October 22, 2014

Historic Preservation Board  
Room 209 City Hall  
Portland, ME 04101

**RE:**  
DEERING STREET RECONSTRUCTION PROJECT

DEERING STREET

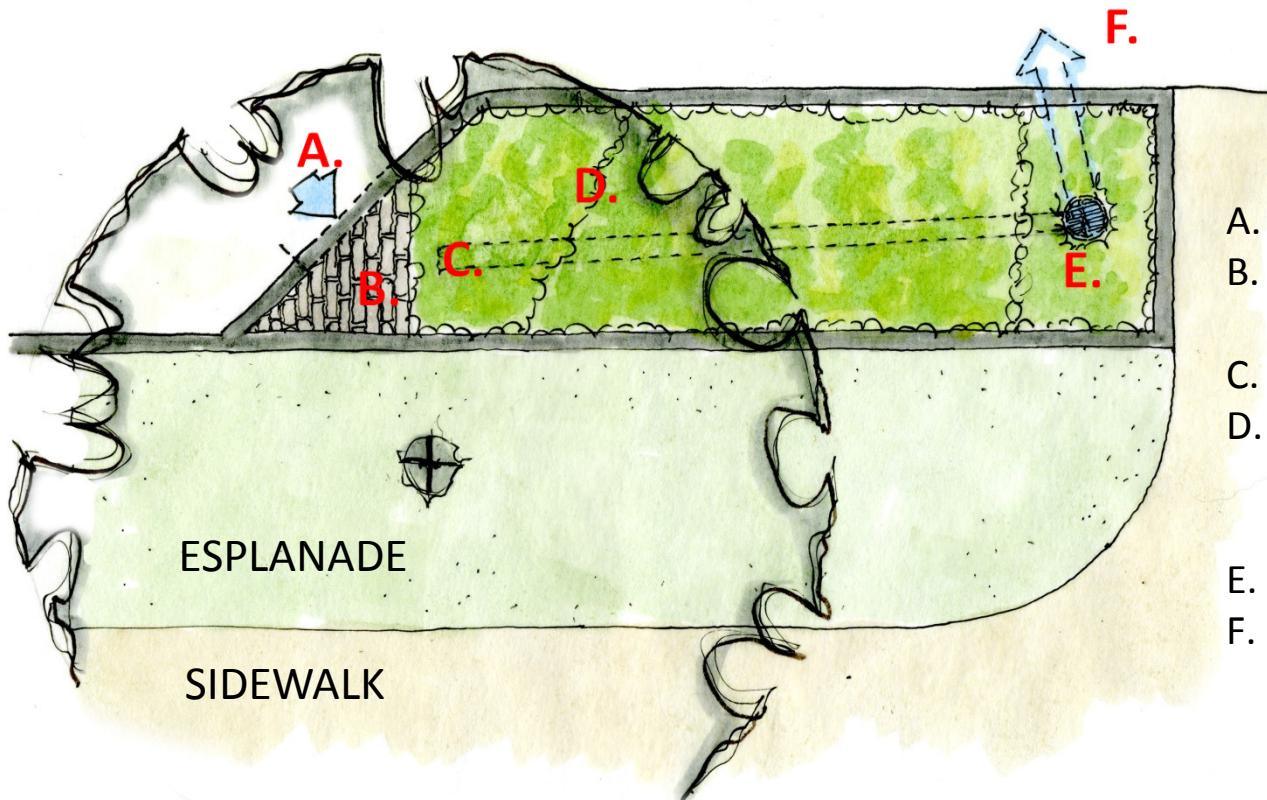
The Public Services Department is committed to a City-wide integration of “green” storm water components to pretreat and minimize runoff. In response to Board comments that the proposed treatment seemed lop-sided, the Department investigated the feasibility of adding curb extensions on the southern side of Deering Street. While these areas would not provide any storm water function, they would mirror the curb line on the opposite side of the street, particularly at key intersections. The City’s traffic engineer reviewed the turning movements and determined that narrowing the travel lane further is not feasible in these locations, particularly in consideration of snow loading. For this reason, the Department is moving forward with the locations originally proposed. As requested by the Board, the design team has prepared photo renderings showing several views of the planted curb extensions. Please reference the enclosed images.

LANDSCAPE PLAN - STATE TO HIGH ST.

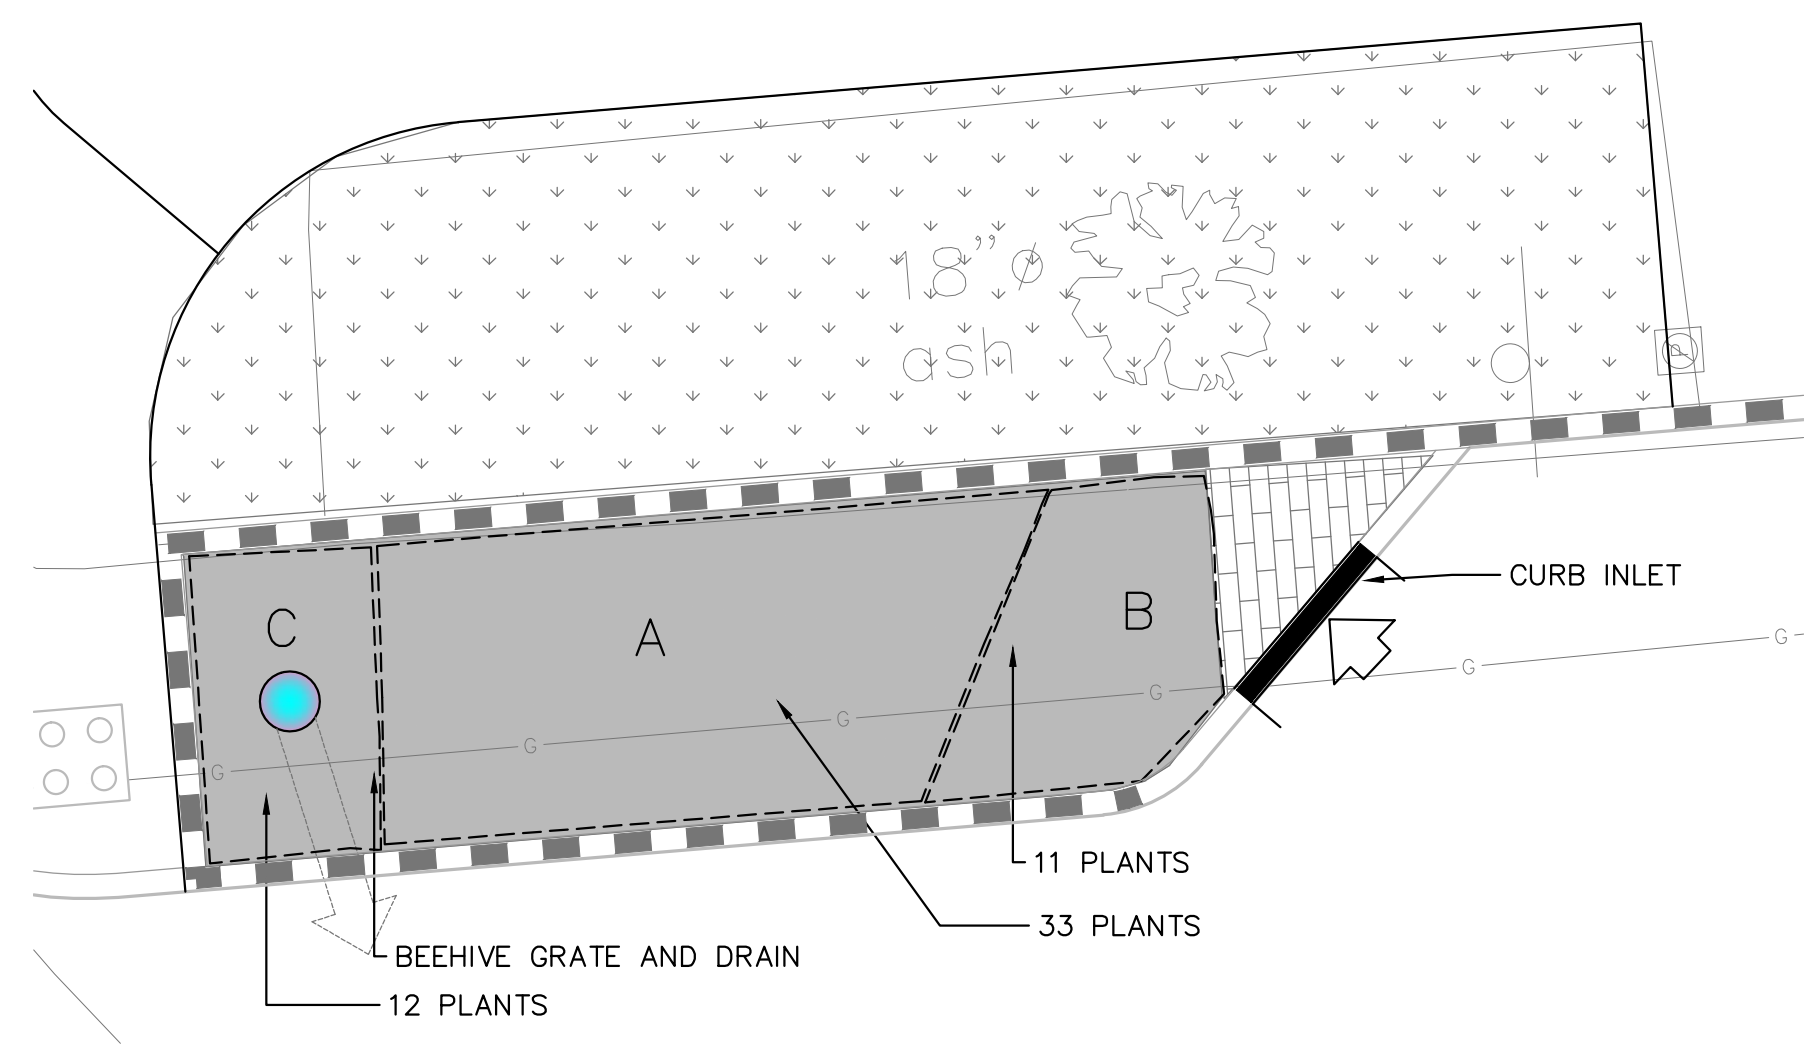
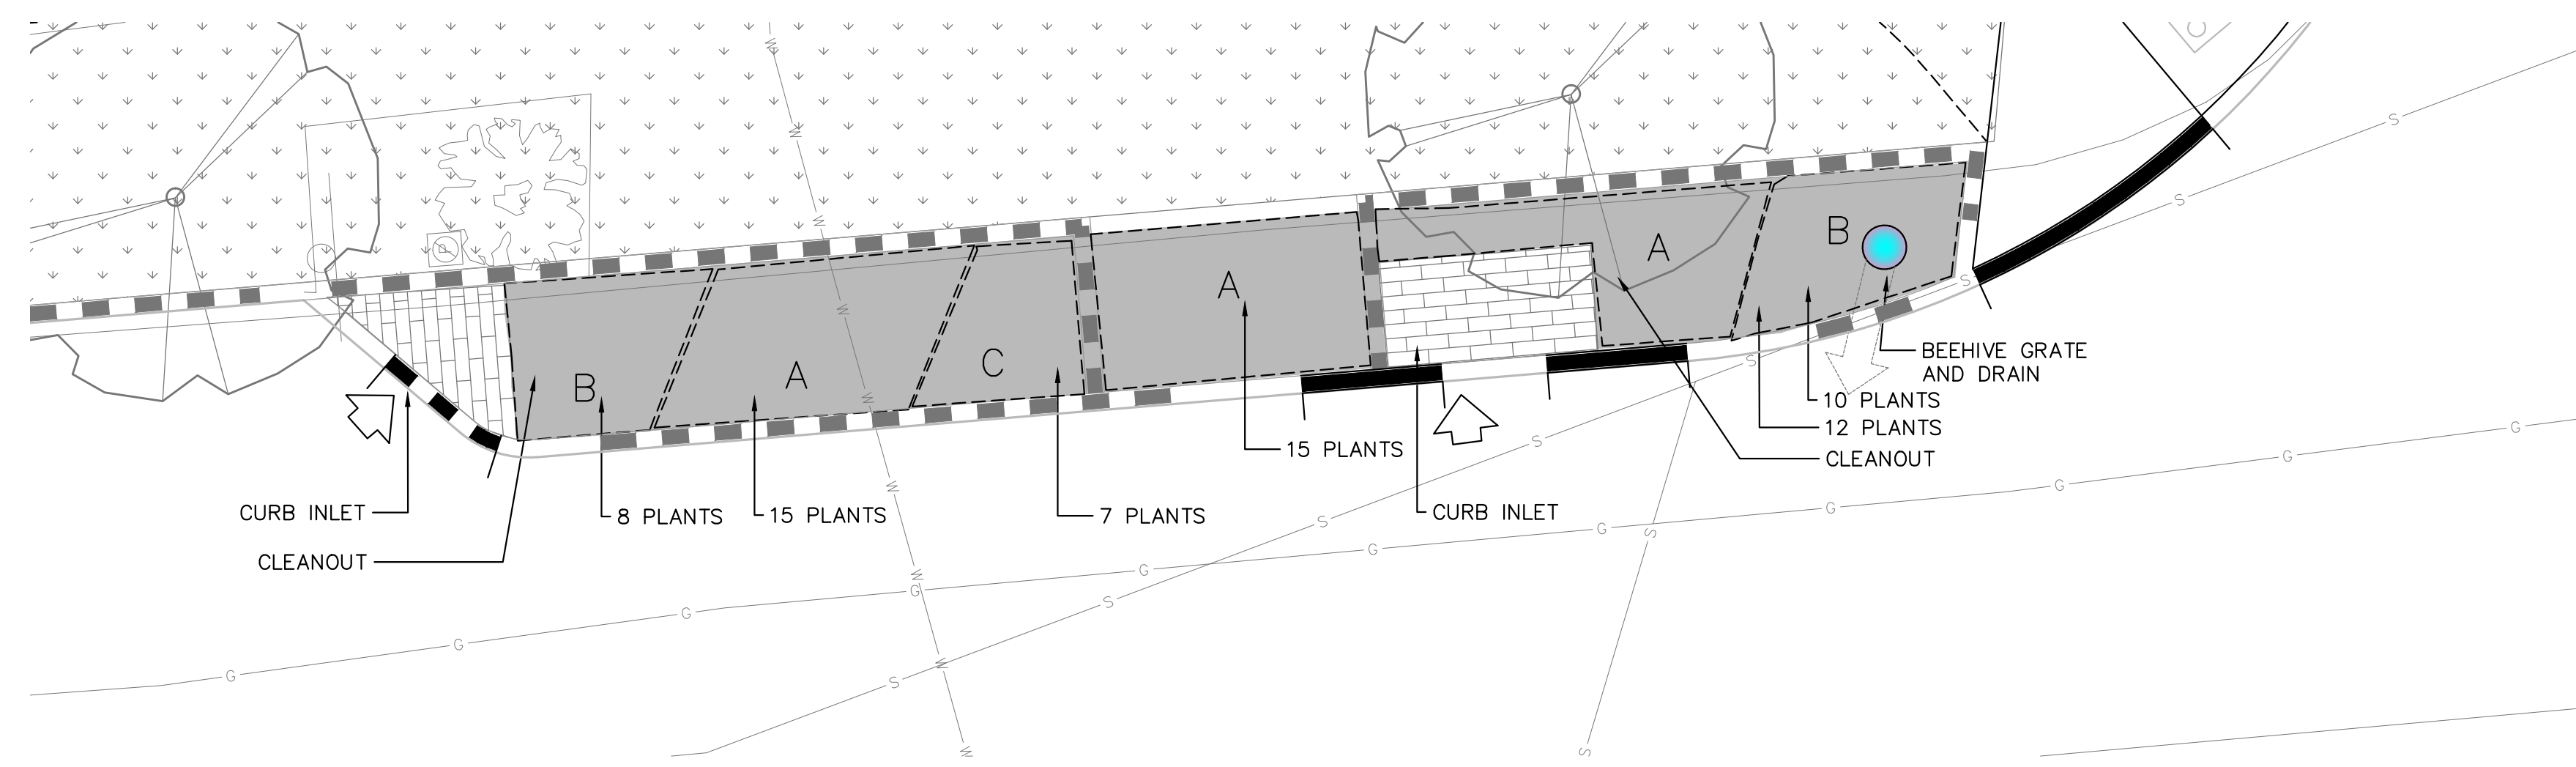
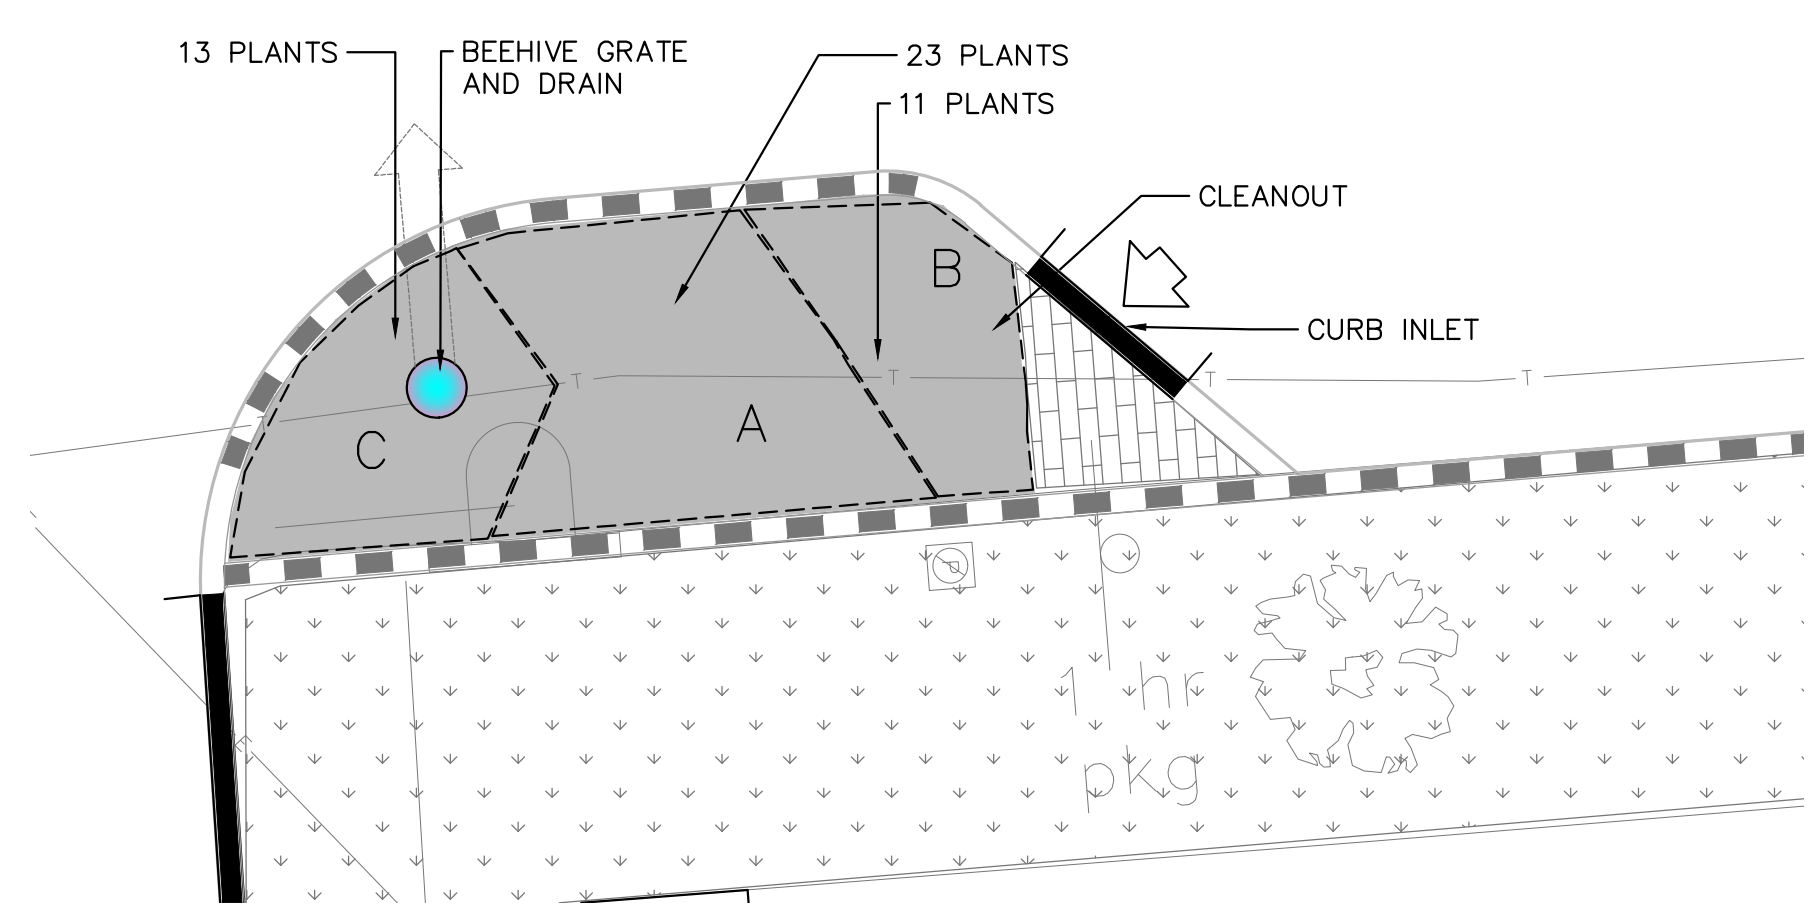
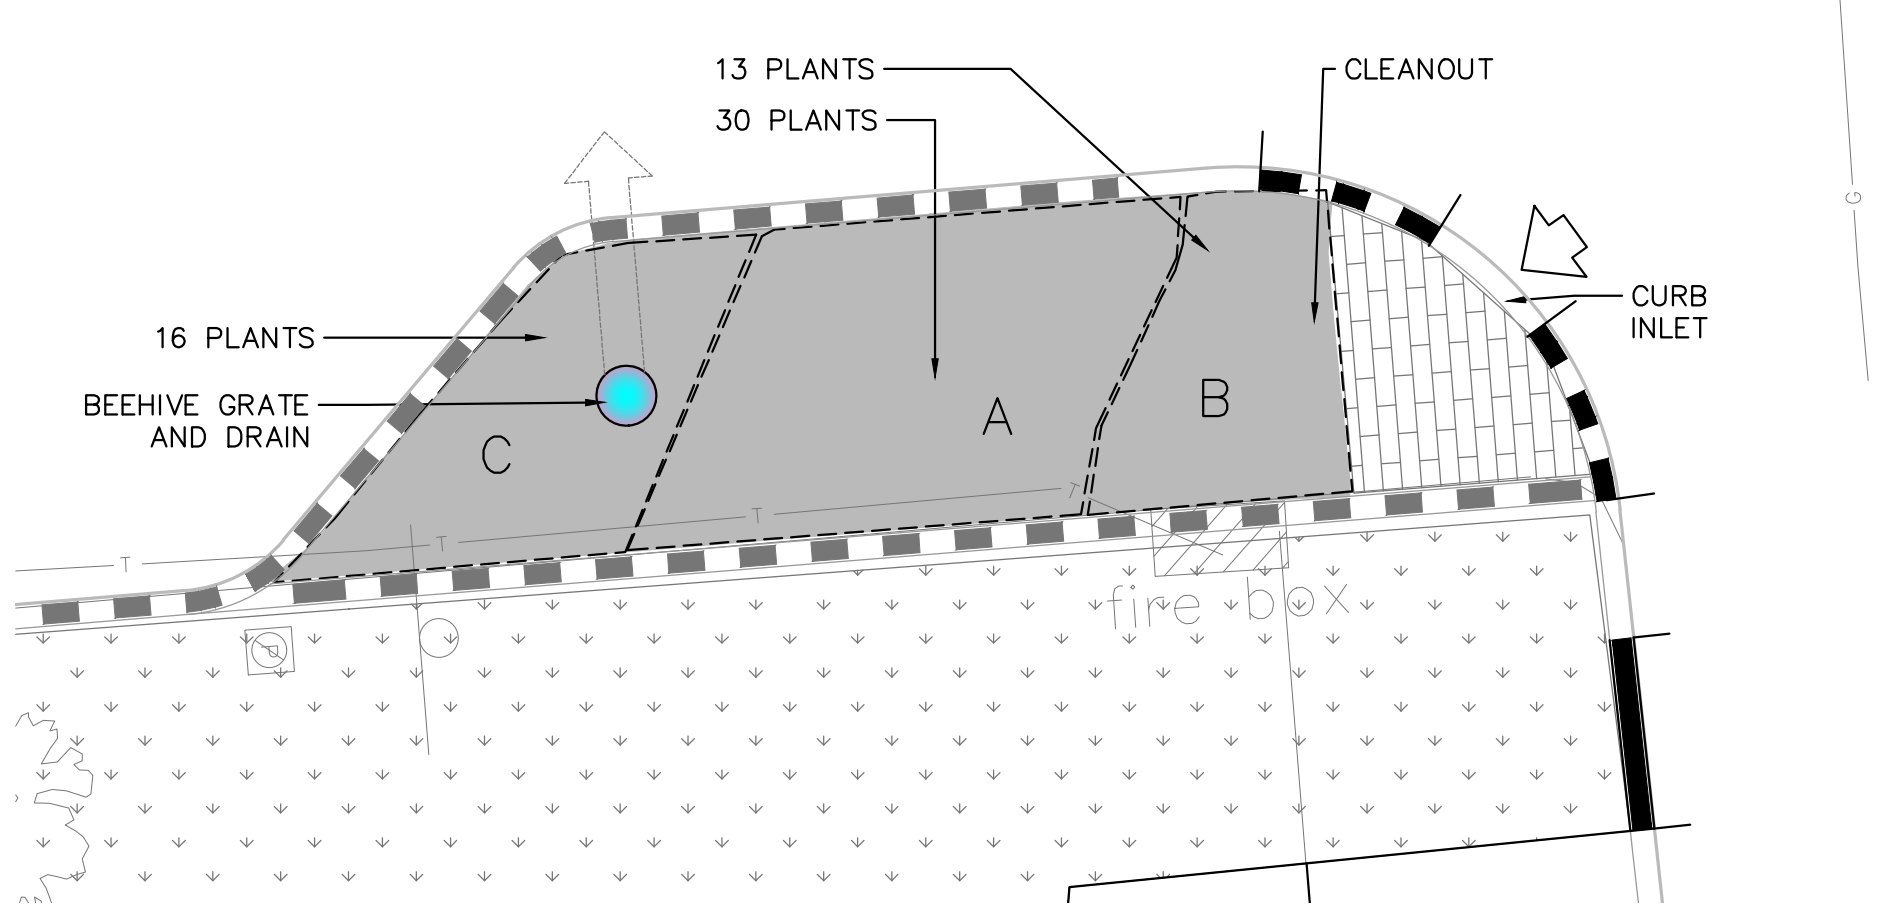
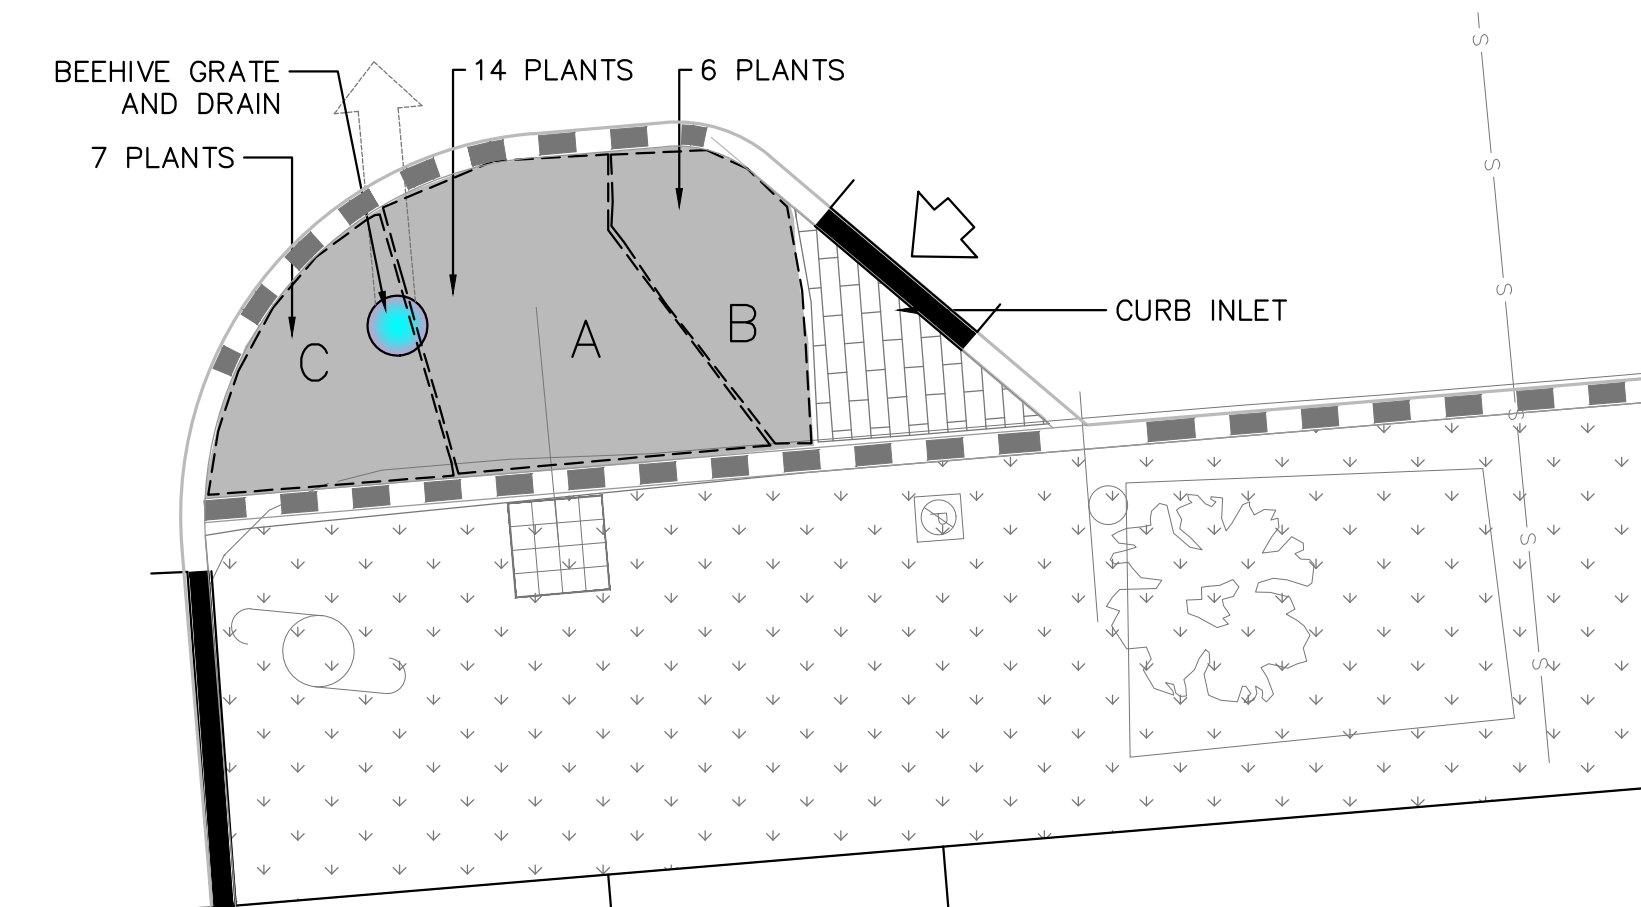
The easterly portion of the State to High Street block includes several historic carriage steps, which will be reset six inches from the back of curb to minimize damage from snow plowing activities.

As described to the Board, the project proposes minimal changes to the established street trees and esplanade areas. On the eastern side of the State-to-High Street block where the sidewalk currently extends sixteen feet to the edge of street, the esplanade areas will be reestablished. Street trees will be added and existing spacing adjusted to achieve conformity with established esplanade areas. At this time, the plan does not include any tree removals. Because this project is coordinated with utility upgrades by Unitil and PWD, there may be
